Fairfield City Council

Submission to Proposed State Significant Development

(SSD 17/8859)

**Proposed Business Hub
1111-1141 Elizabeth Drive, Cecil Park**

Figure 19: Amended Proposal showing Road Configuration

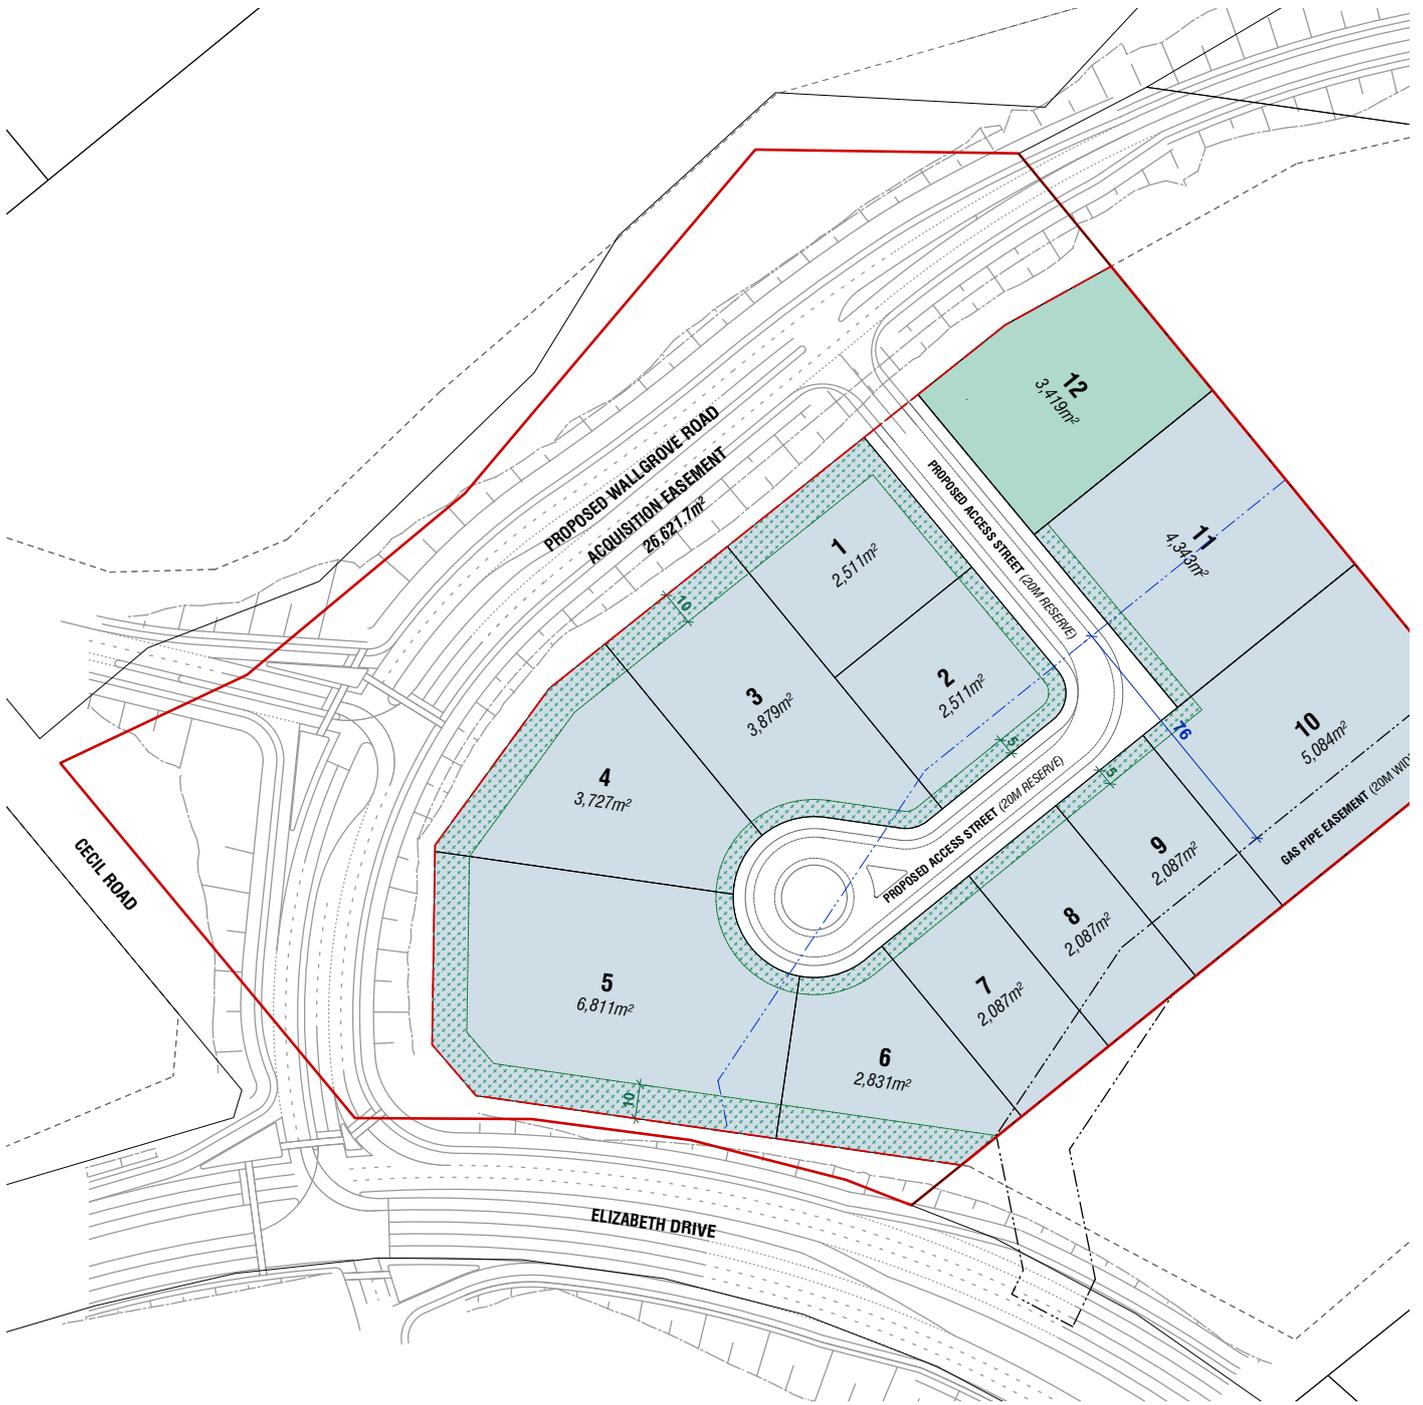
- The installation of a roundabout at this intersection is considered unsuitable given the function of Elizabeth Drive and Cecil Road (both now and into the future), type of vehicles using the intersection, the current levels of traffic and expected significant increase in regional traffic along Elizabeth Drive as a result of development associated with the Western Sydney Airport at Badgerys Creek and Aerotropolis development.

- The above concerns are compounded by the degree of site development associated with the proposed highway service centre at 1111-1141 Elizabeth Drive and high levels of traffic movement generated by the proposal, lack of service/turning lanes from the site to/from Cecil Road, amount of queuing that would occur on Cecil Rd/Elizabeth Drive and associated detrimental impacts on traffic safety in the area.

Although the RMS and Transport for NSW would make the ultimate determination on the suitability of the intersection treatment of Elizabeth Drive and Cecil Road, Council advises the DP&E that it does not support the provision of a roundabout at this location having regard to the above issues raised.

- Signalisation of the intersection of Elizabeth Drive and Cecil Road;
- Specific reference to the proposed land uses within the conditions of consent;
- Inclusion of an *Unexpected Finds Protocol* and appropriate conservation management measures as conditions of consent; and
- Confirmation that the floor space generated is included within the 2% allowed for business hub development within the Parklands under the Western Sydney Parklands Plan of Management 2030.
